**KIRKLEES METROPOLITAN COUNCIL
INVESTMENT & REGENERATION SERVICE**

DELEGATED DECISION TO DETERMINE PLANNING APPLICATIONS

Reference No:	2023/62/93369/E
Site Address:	137, Quaker Lane, Hightown, Cleckheaton, BD19 5JG
Description:	Erection of part two storey rear extension and dormer extension
Recommending Officer:	Jennifer Booth

DECISION - REFUSED

Proposed Floor Plans

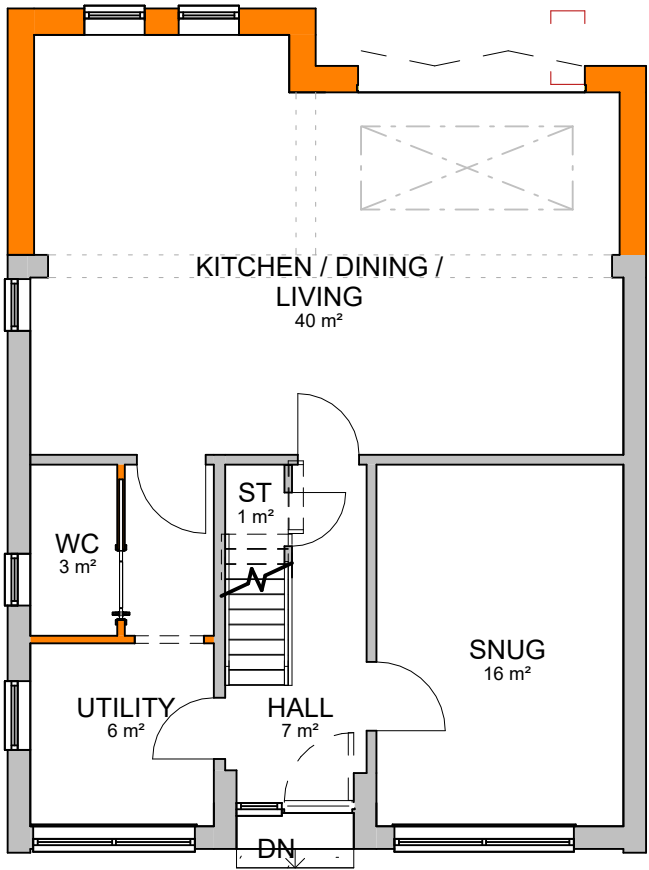
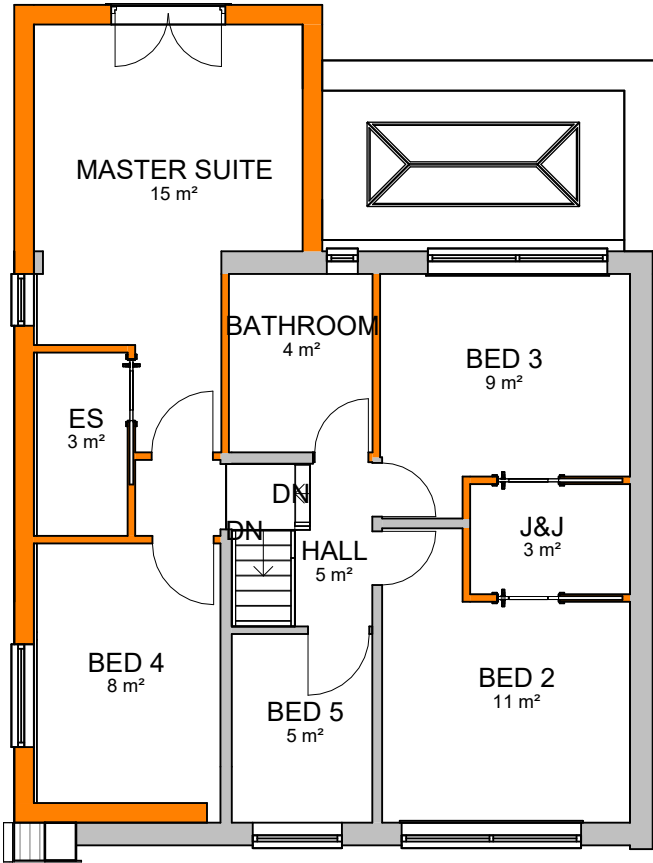
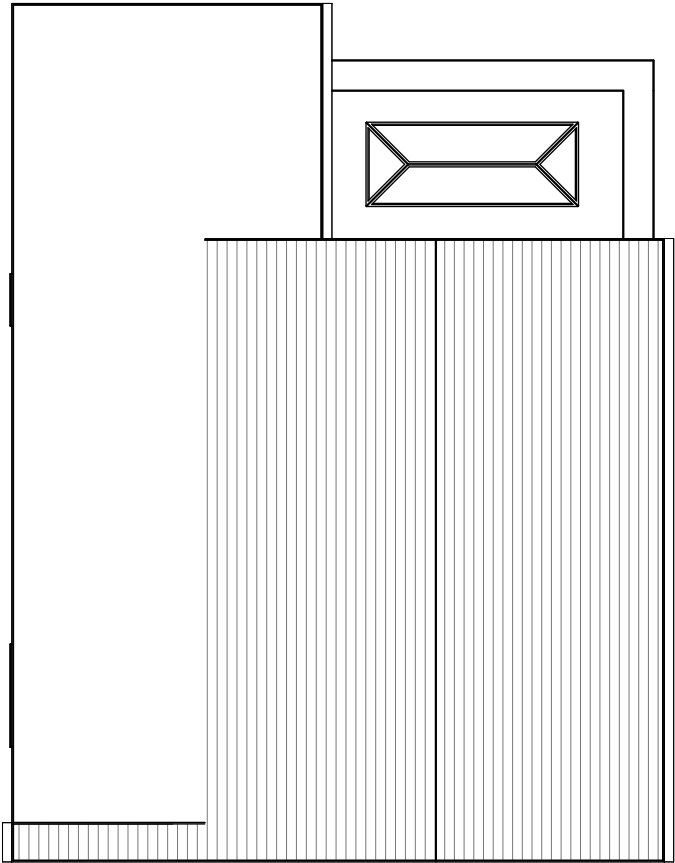
Whilst it is appreciated that the first floor element is replacing an existing dormer and would not increase the width of the dwelling, the design has a large expanse with a flat roof and boxy form. The side elevation of the property is prominent and as flat roof forms do not generally represent good design, in this instance the design with the use of cladding would form an incongruous feature within the street scene. It is noted that the properties on Quaker Lane are a mix of styles. That being said, the alterations proposed would be out of character with the wider area. The first floor side extension is therefore considered to be unacceptable in terms of visual amenity.

The rear extensions have a limited projection and would allow for the retention of a reasonable amenity space. The scale is therefore acceptable. However flat roof forms are not generally considered to represent good design. The first floor element would be prominent and in this instance, resultant appearance would be incongruous with the host and wider area and therefore is not considered to be acceptable. The single storey element would be limited in terms of its height with limited views in the wider area and could be considered to be acceptable. However, overall the two storey rear extension is not considered to be acceptable in terms of visual amenity.

The plans indicate the external walls of the dwelling would be clad with a combination of render and composite cladding which would alter the appearance of the dwelling. Whilst it is appreciated that there is a mixed palette in the wider area, the overall design together with the materials proposed would result in the dwelling forming an incongruous feature in the street scene. The alterations are therefore considered to be unacceptable in terms of visual amenity.

The proposals, by reason of the design, use of significant flat roofing and materials including the mix of render and cladding would result in the formation of a prominent and incongruous form of development which is considered to be harmful to the character of the host property and the wider street scene. To permit the proposals would be contrary to Policy LP24 of the Kirklees Local Plan, KDP1 & KDP2 of the House Extensions & Alterations SPD and advice within chapter 12 of the National Planning Policy Framework.
